CITY OF ALBUQUERQUE

July 27, 2023

Re: Mata Auto Garage
142 40th St. SW
Traffic Circulation Layout
Architect's Stamp 03-03-23 (K12-D037)

SHEET TITLE:
ARCHITECTURAL SITE PLAN

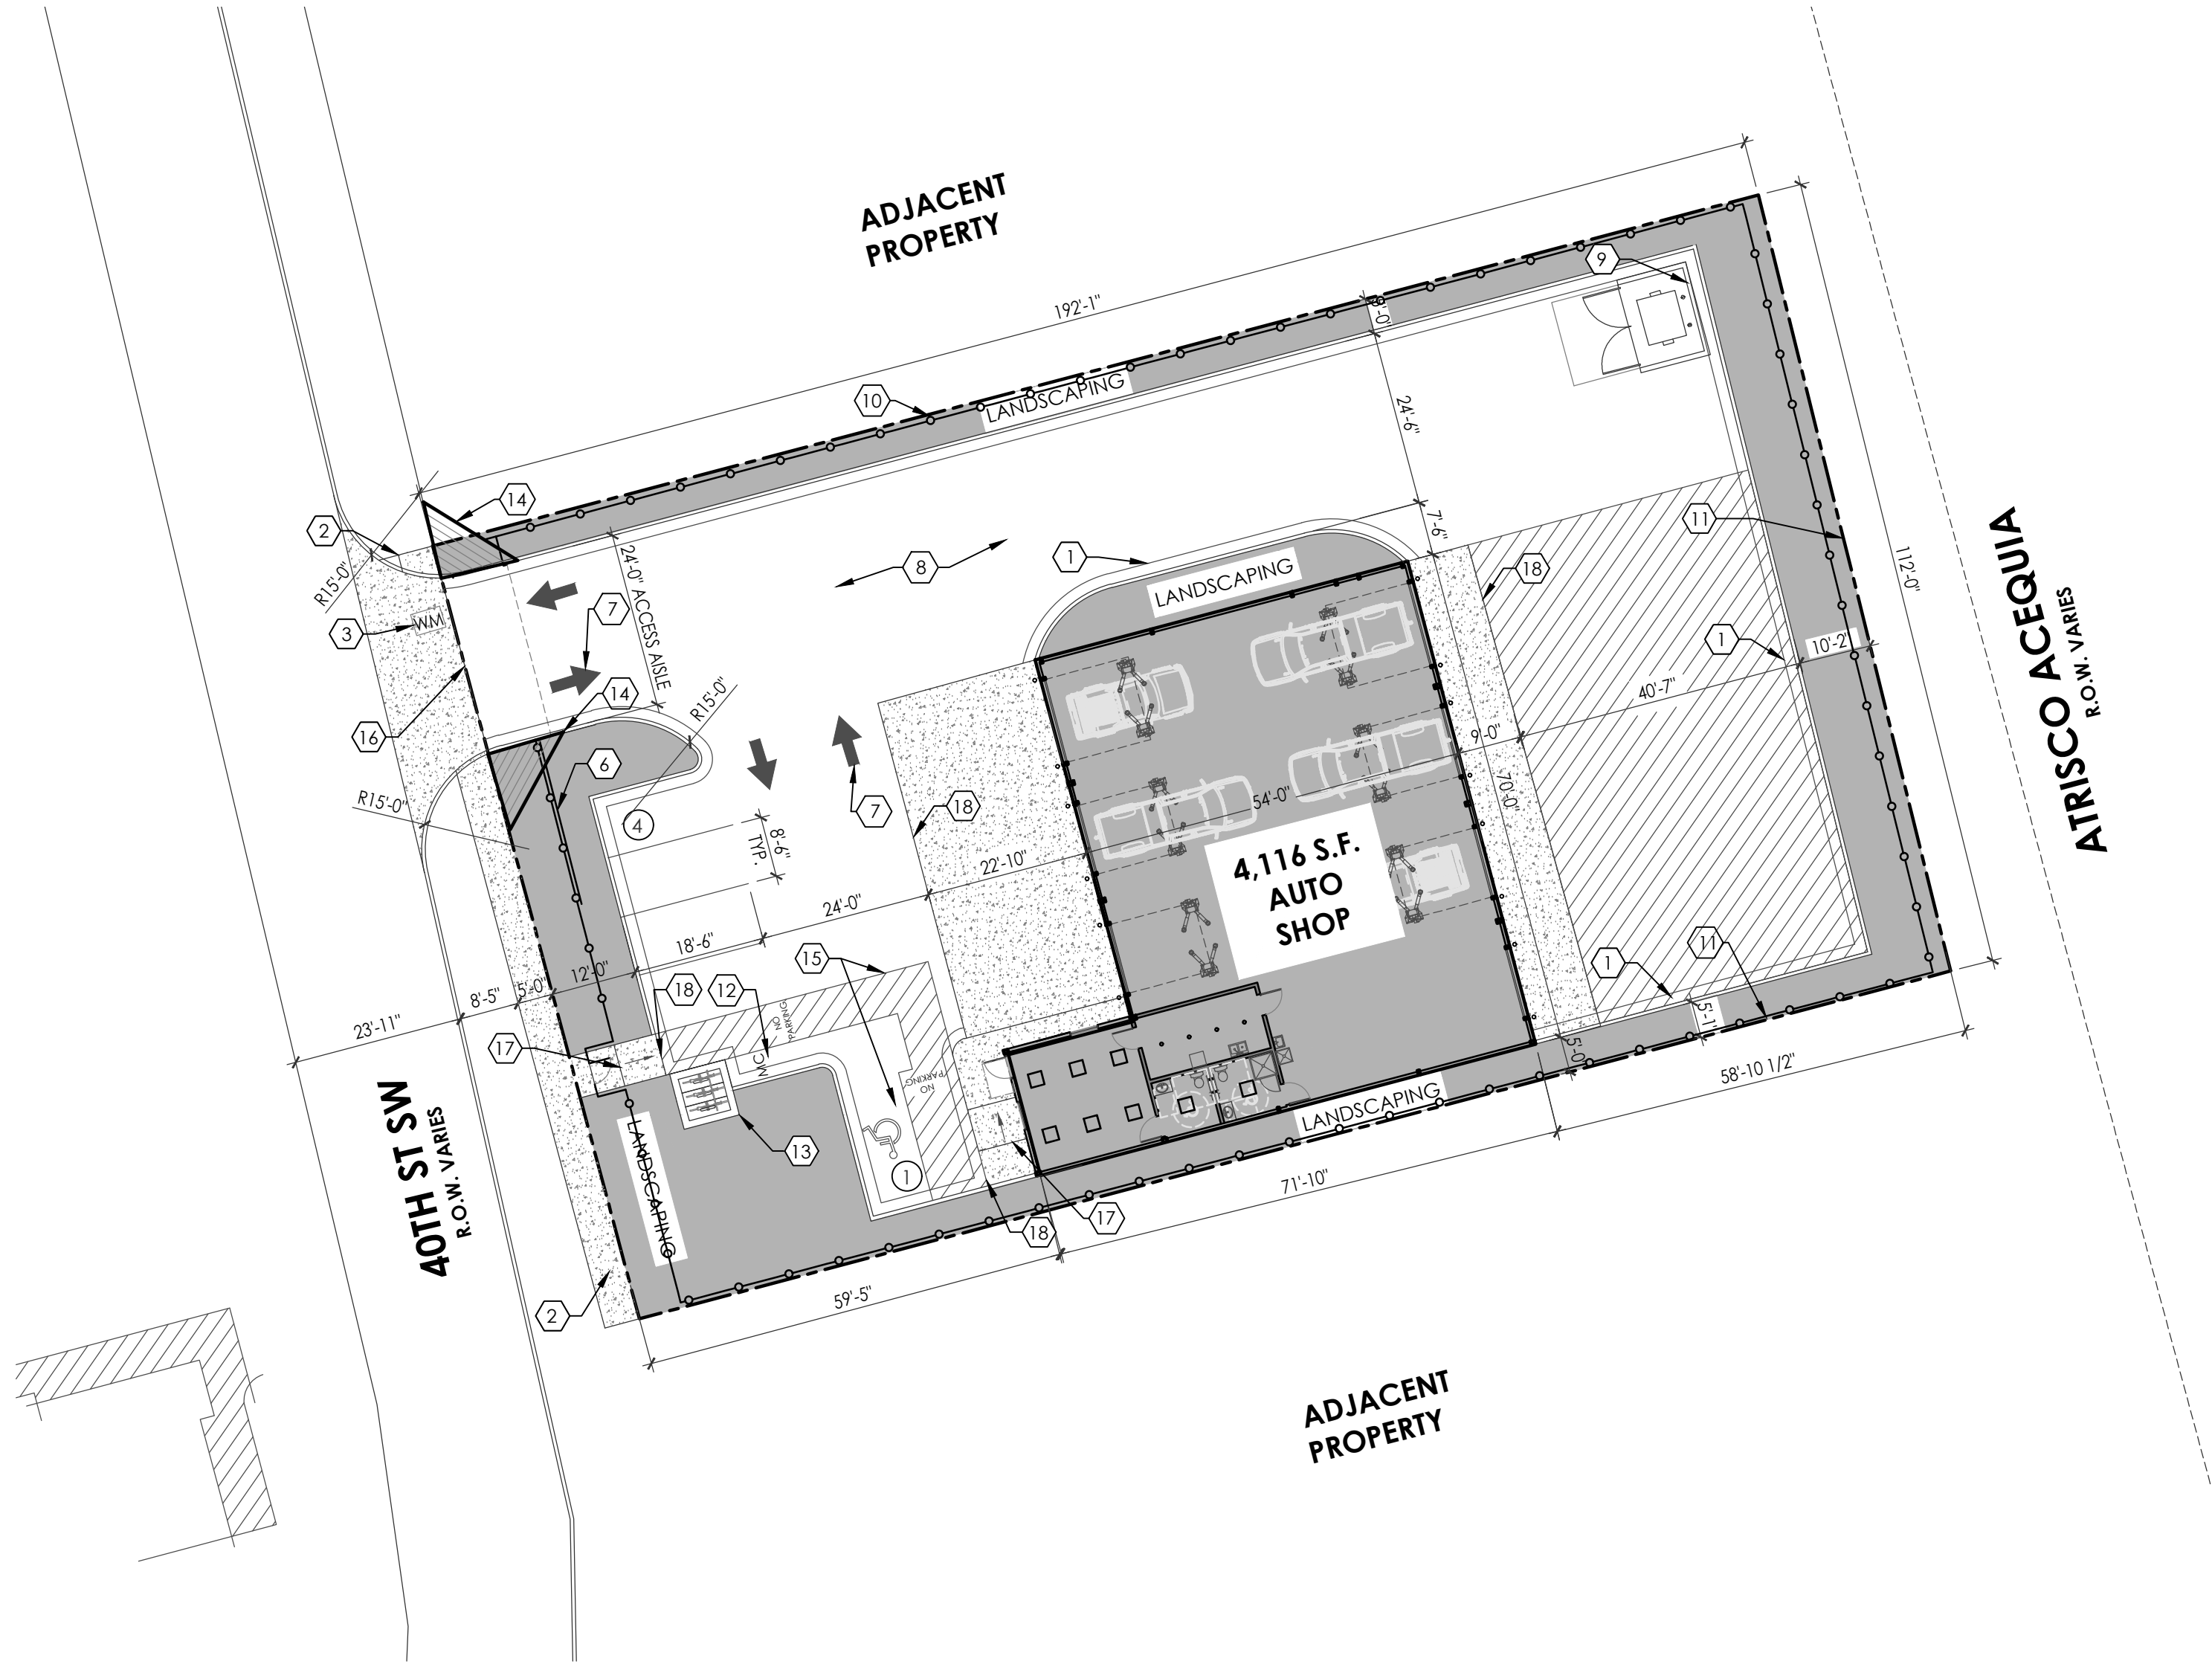
1. List the number of Bicycle and Motorcycle parking spaces required by the IDO.
2. Identify all existing access easements and rights of way width dimensions.

3. Identify the right of way width, medians, curb cuts, and street widths on 40TH St.
4. Show on the site plan site access's width and provide driveway design details.

5. Keynote 7: please reference COA std dwg 2430 for the proposed sidewalk.
6. Please show on the site plan the width for the proposed parking spaces. Minimum standard and ADA stall parking width is 8.5 ft.

7. Sheet TCL-2 is missing.
8. The ADA accessible parking sign must have the required language per 66-7-352.4C NMSA 1978 **"Violators Are Subject to a Fine and/or Towing."** Please call out detail and location of signs.

9. Motorcycle parking spaces shall be designated by its own conspicuously posted upright sign, either free-standing or wall mounted per the zoning code.

10. The pavement marking "MC" should be shown in the opposite direction for motorcycles entering the parking space.
11. Per the IDO, a 6 ft. wide ADA accessible pedestrian pathway is required from the public sidewalk to the building entrances. Please clearly show this pathway and provide details.

12. Per DPM, a 6 ft. wide ADA accessible pedestrian pathway is required from the ADA parking stall access aisles to the building entrances. Please clearly show this pathway and provide details.

13. ADA accessible pedestrian pathway should not be placed behind parking space or adjacent to a vehicular way. Vehicle and pedestrian/wheel chair conflicts should be avoided as much as possible.

14. All sidewalks along streets should be placed at the property line.

15. Curbing should be installed to delineate landscape, parking, and pedestrian ways and identify points of access. Please call out detail and location of barrier curb.

16. Refuse vehicle maneuvering shall be contained on-site. The refuse vehicle shall not back into the public right of way.; provide a copy of refuse approval.
